**WEST SUSSEX COUNTY COUNCIL
PLANNING SERVICES CONSULTATION**

SUBJECT: R/215/17/PL - 2 No. employment units for Class B1 (B1 Business) and/or Class B8 (B8 Storage or Distribution) with ancillary trade counter & office (Class B1a)) together with associated access, car parking & landscaping.

Units 6 & 7, Brookside Avenue, Rustington, West Sussex, BN16 3LF

RECOMMENDATION: No Objection

Proposed Redevelopment
Units 6 & 7
Brookside Industrial Estate
Brookside Avenue
Rustington, West Sussex
Site Plan

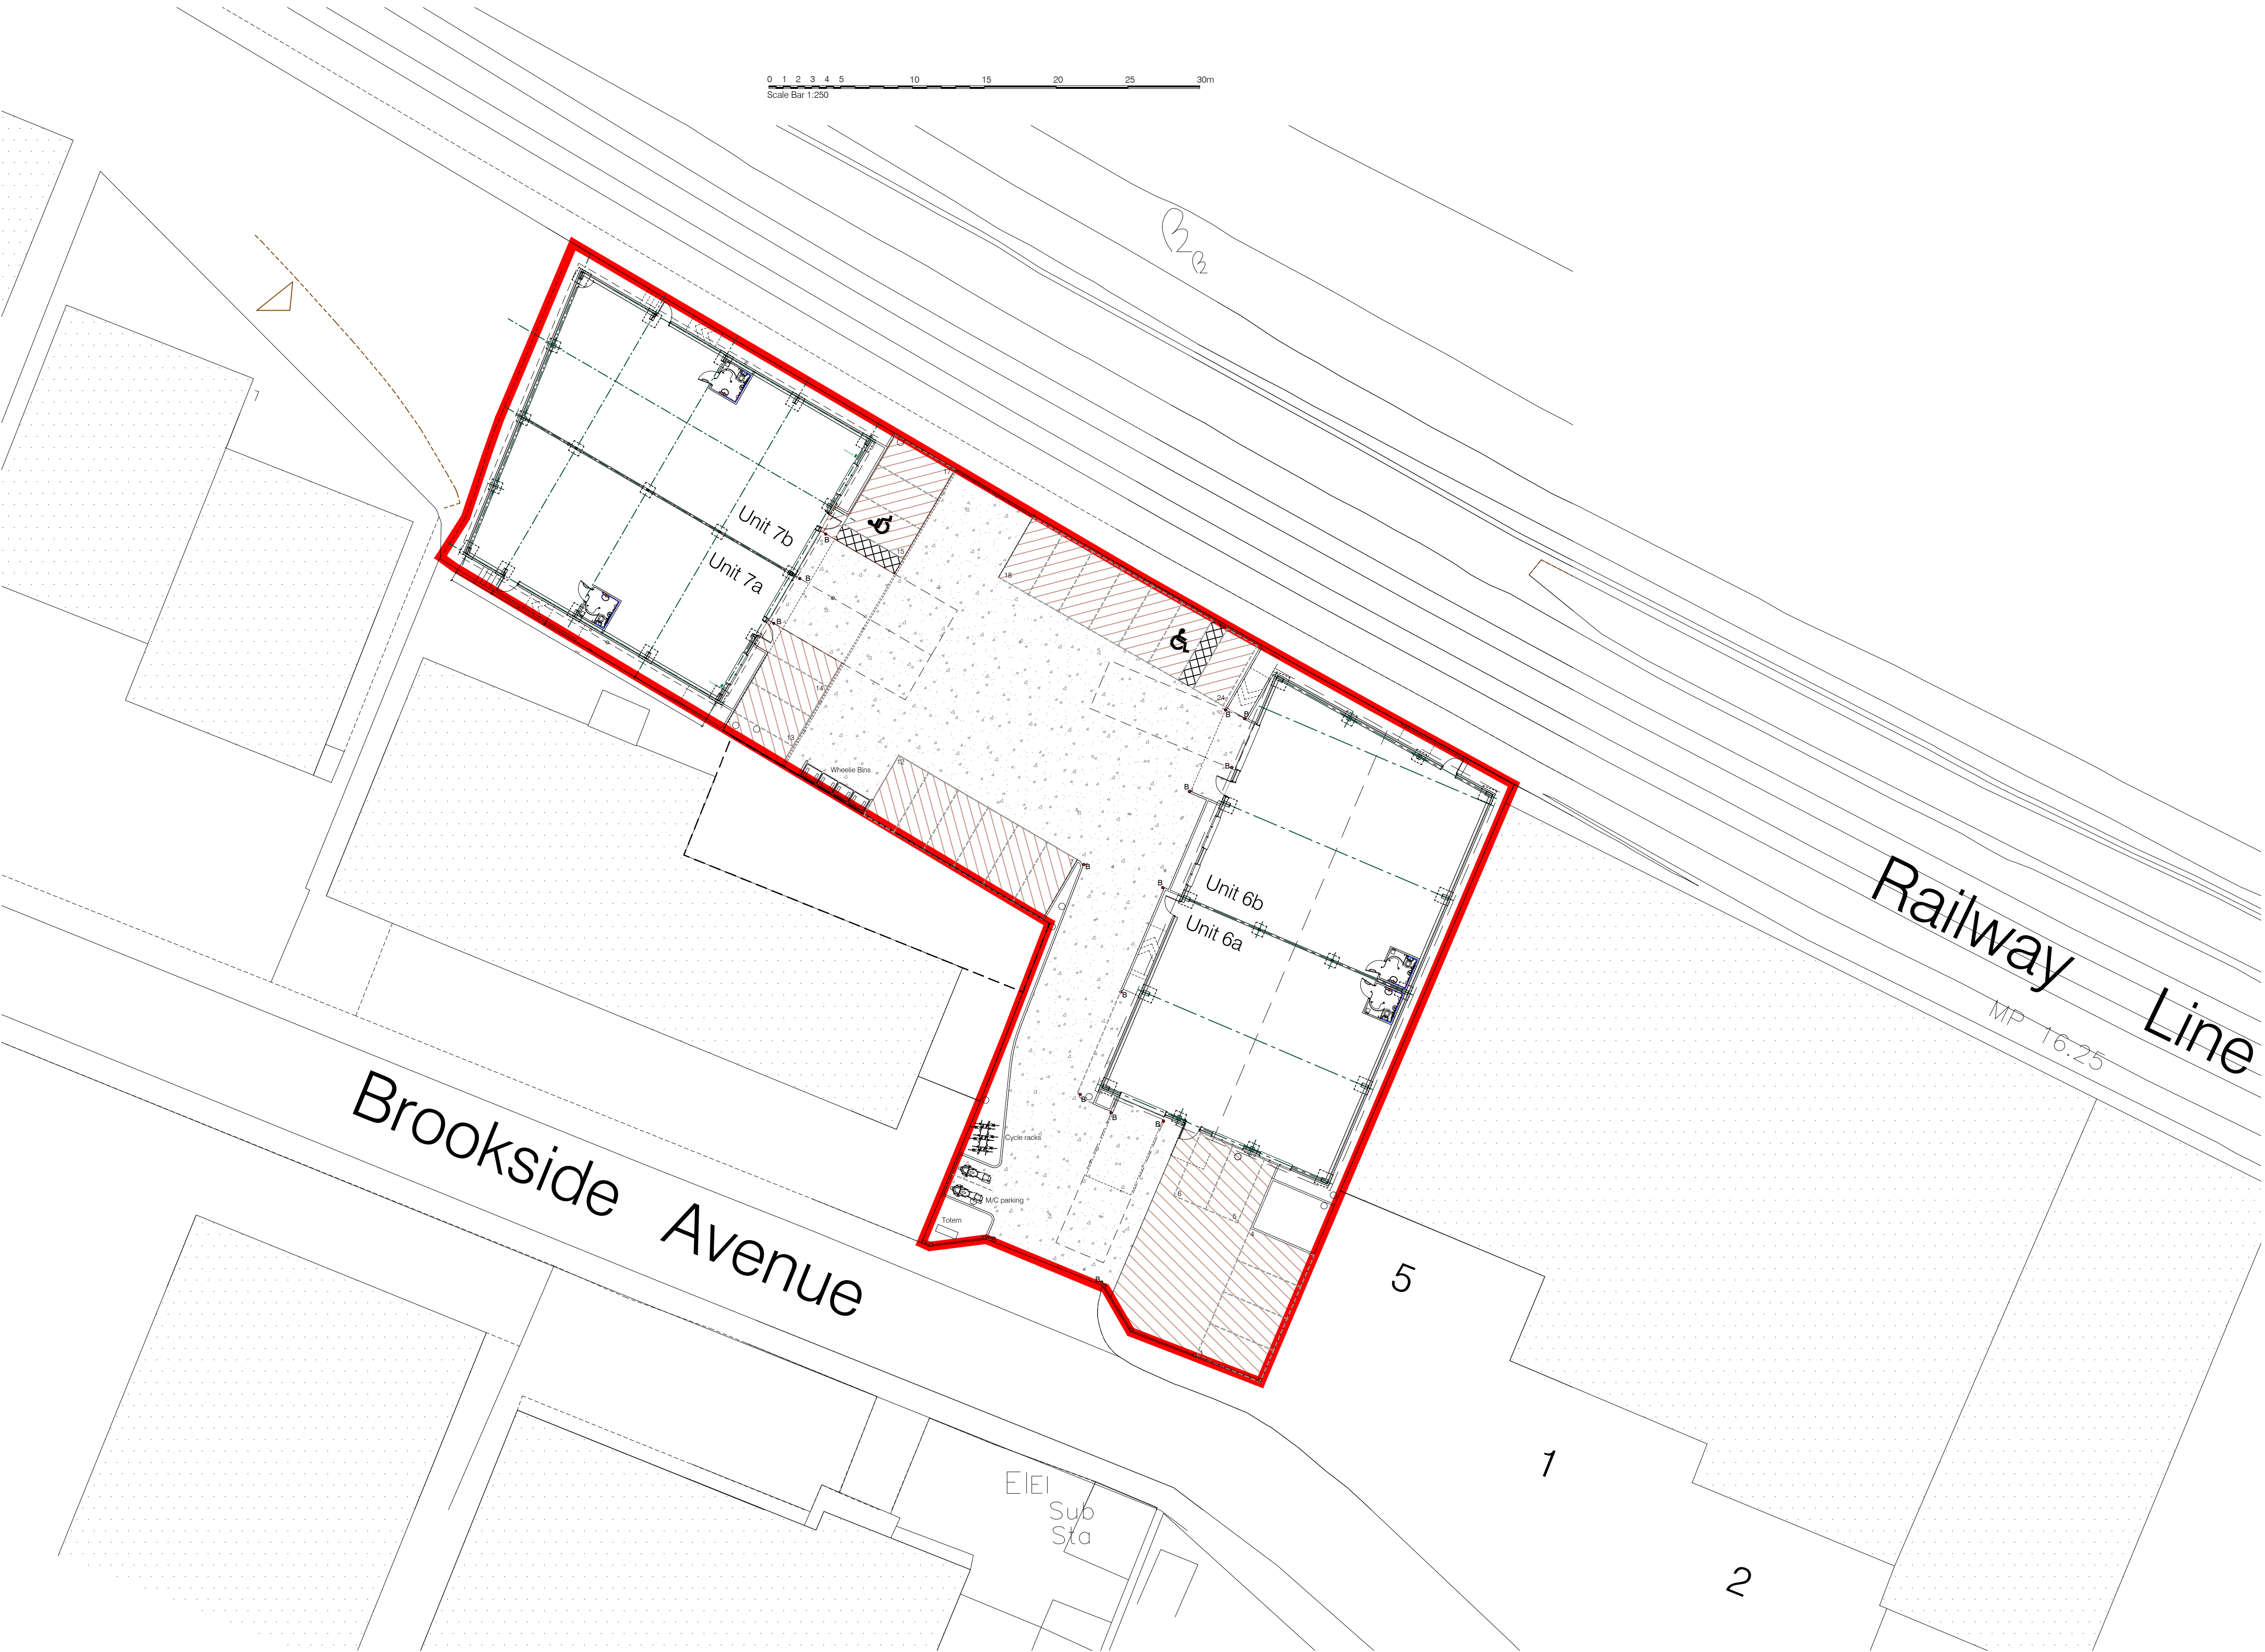
From inspection of the plans, there appears to be no apparent visibility issue at the point of access onto Brookside Avenue. I have also checked the most recently available verified accident records, which reveals there have been no personal injury accidents in the vicinity of the existing point of access.

24 car parking spaces are proposed, including 2 disabled parking spaces. A flexible permission is sought with potentially B1 or B8 operating from the site. Of these, the B1 use would generate the highest car parking demand and based upon the maximum parking standards 31 car parking spaces may be provided. A B8 use class has been applied and based upon this a maximum of 9 car parking spaces (+ 2 Lorry Spaces) may be provided. Given the flexible permission sought, the proposed car parking provision does fall within the maximum parking standards.

The development hereby approved shall not be occupied until such time as the car parking has been laid out in accordance with the approved plans.
